Appeal Decision

Appeal Ref: APP/R5510/W/21/3277296

84 East Road, West Drayton UB7 9HA

- The appeal is made under section 78 of the Town and Country Planning Act 1990 against a refusal to grant planning permission.
 - The appeal is made by Mr & Mrs Agrawal against the decision of the Council of the London Borough of Hillingdon.
 - The application Ref 31005/APP/2020/3975, dated 1 December 2020, was refused by notice dated 27 May 2021.
 - The development proposed is described as, "New Dwelling House".
-

NOTES:  
All dimensions must be checked on site and not scaled from this drawing.

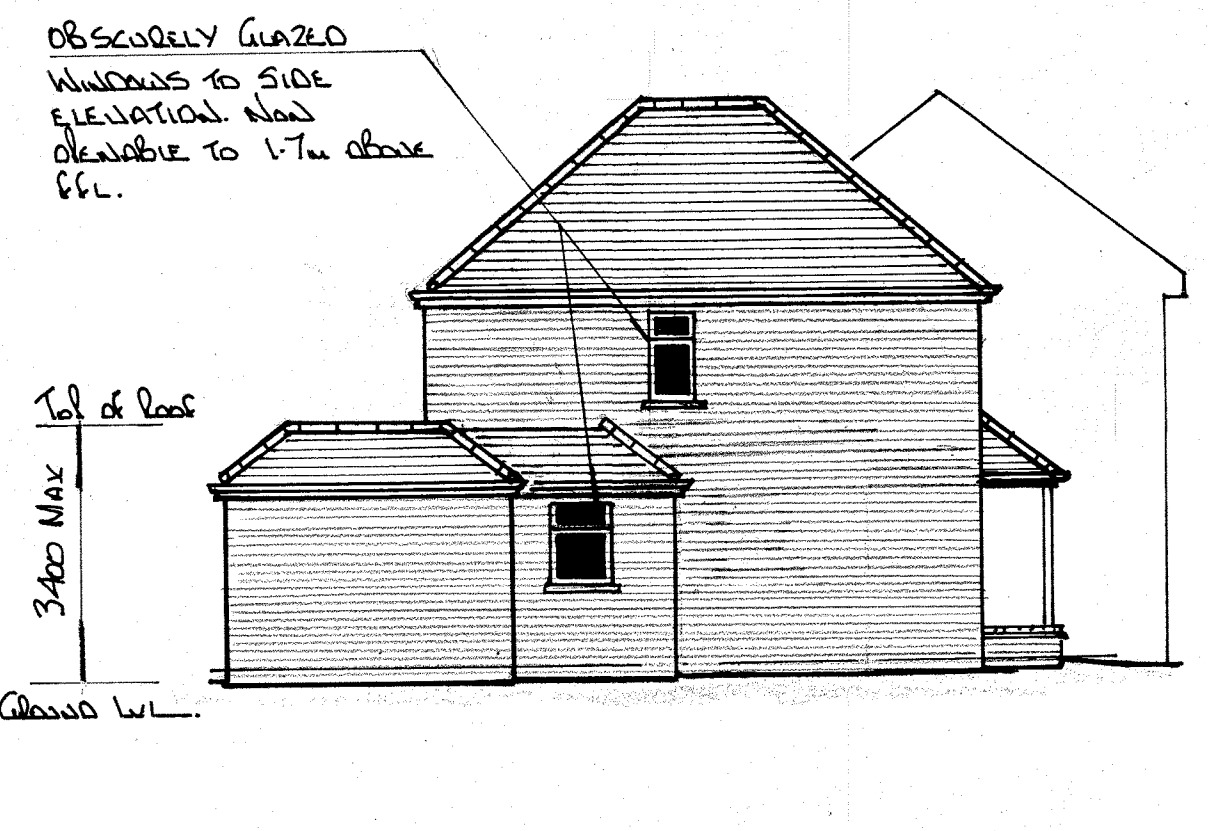
5. Nevertheless, the proposed dwelling would project very close to the existing single-storey side projection at No 86, thereby removing the majority of the pockets of small visual gaps that presently exist between Nos 84 and 86 at ground-floor level. More importantly, although it would not completely erode the existing gap between Nos 84 and 86 at first-floor level, it would subsume a substantial portion of that gap. As such, the proposal would unduly reduce the sense of spaciousness referred to above. Moreover, the proposed hipped roof, with its lower 'link' detail, would appear incongruous in the street scene considering the absence of this feature on many nearby properties. Taking all this into account, the proposal would cause material harm to the character and appearance of the area.
